Mr Jason Willcox  
2 Quiet Waters Close  
Roundstone Lane  
Angmering  
BN16 4DG

20<sup>th</sup> February 2022

I am writing to you regarding planning application A/268/21/PL, made by Caffyns Plc to build a Volvo dealership and workshop on land east of Roundstone Lane, Angmering.

Proposed Site plan- 1:500 @ A3

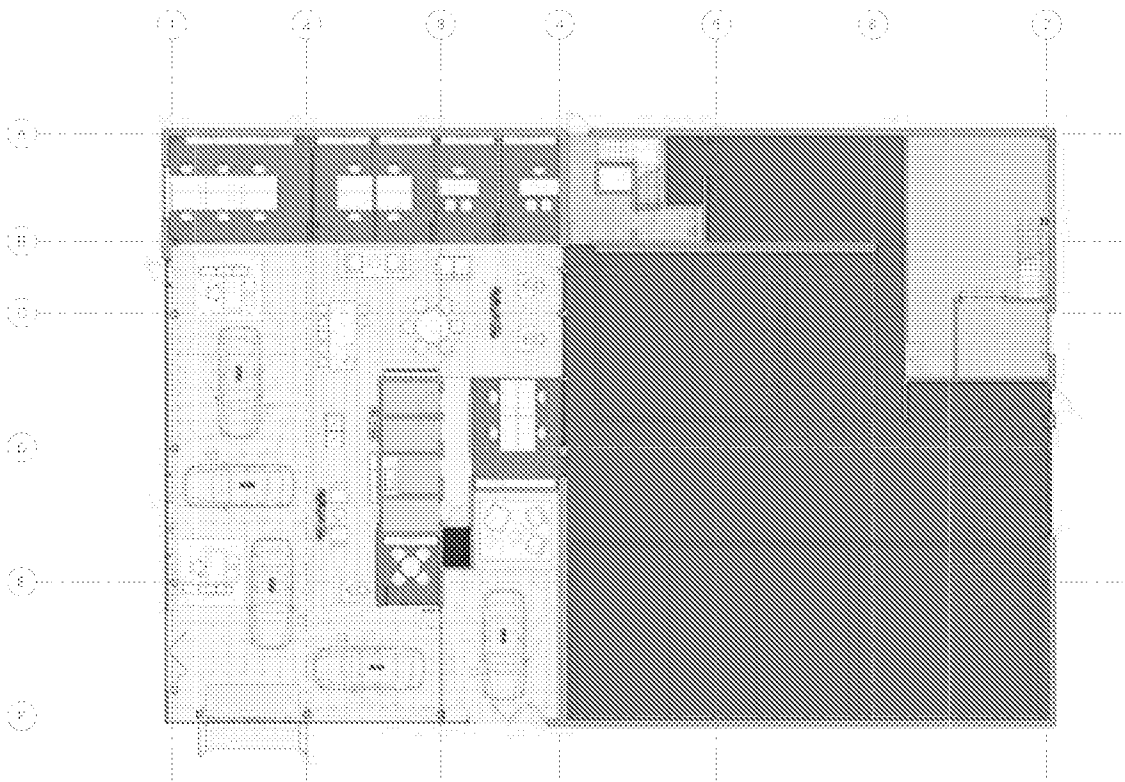
**1. Plot 5 boundary and residential garden not clearly marked on many drawings /plans.**

It appears that our boundary (Plot 5, No. 2 Quiet Waters) is not accurate or clearly defined in many of the plans and statements. As supporting evidence, I have previously provided our land registry document and the letter confirming drafting of Deed of Transfer.

North Elevation

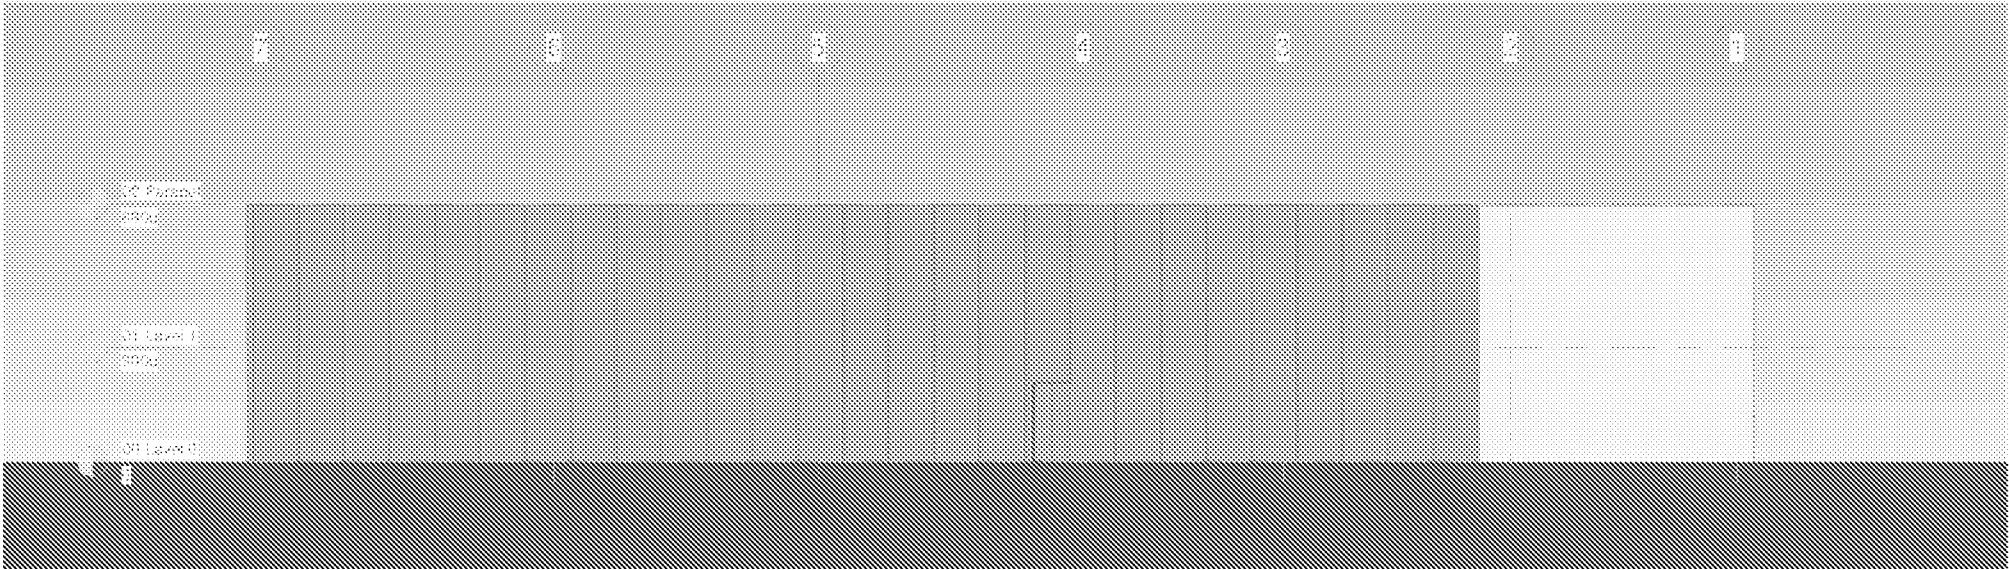
As we have a direct boundary with Caffyns land, given the height of the building and that the final planting and landscaping scheme is still to be confirmed, I hold a concern on the impact of natural light into our home (plot 5). Conversely, I also hold a concern regarding light pollution that may be caused by the security lighting along the boundary. To further my decision making, it would be helpful to have further details on the planting scheme for our boundary with Caffyns.
